Your Ref
P/94/15/PL
Our Ref
PLAN-011256
Date
22/10/2015

Proposal: 3 No. detached bungalows with garage, parking & deck
(resubmission following P/12/15/PL).
Site: Land to the east of 29 Harbour Road, Pagham, PO21 4TF.
P/94/15/PL

Location Plan

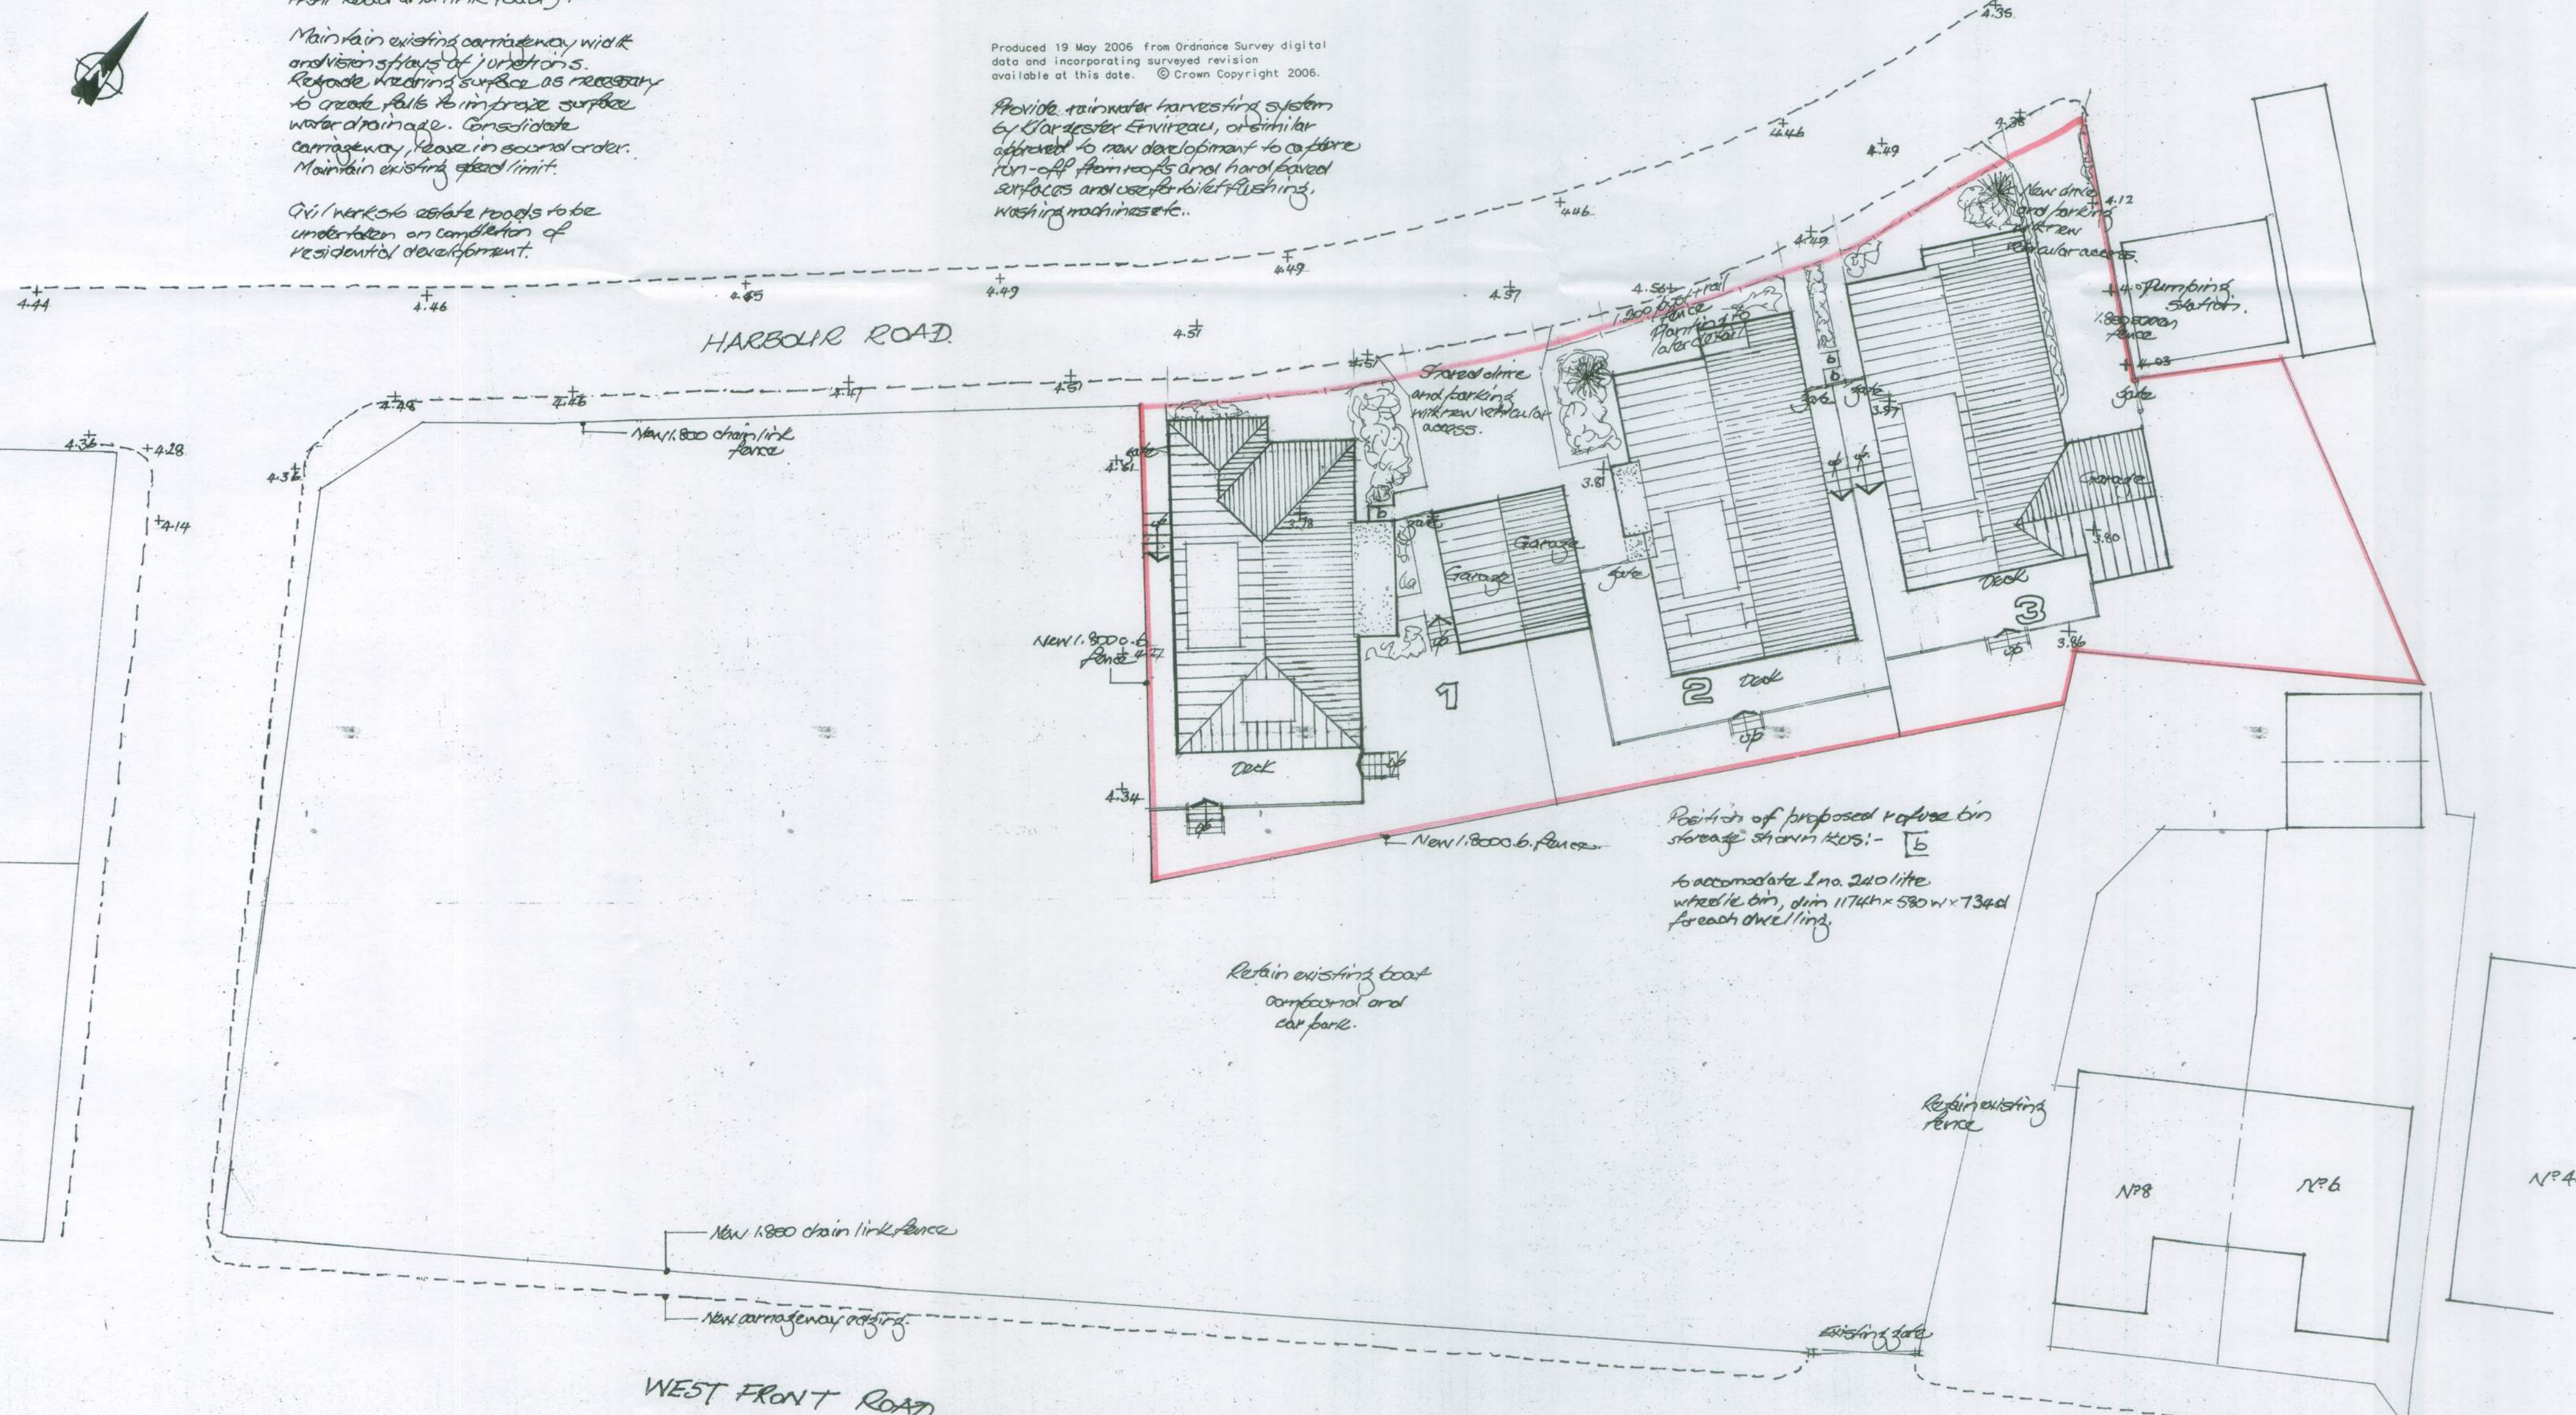
Southern Water objects against the proposed layout. Due to the vibration, noise and potential odour generated by sewage pumping stations, no habitable rooms should be located closer than 15 metres to the boundary of a proposed pumping station site.

The applicant has proposed a rain water harvesting system that will be used for toilet flushing. Such systems, whilst acceptable in principle, must be installed and maintained to high standards to ensure the protection of the public water supply and avoid cross contamination.

We would request that any planning consent is conditional upon the approval of the details of the rainwater harvesting system, prior to commencement of the development and upon the approval of a maintenance regime for the system, prior to occupation of the development.
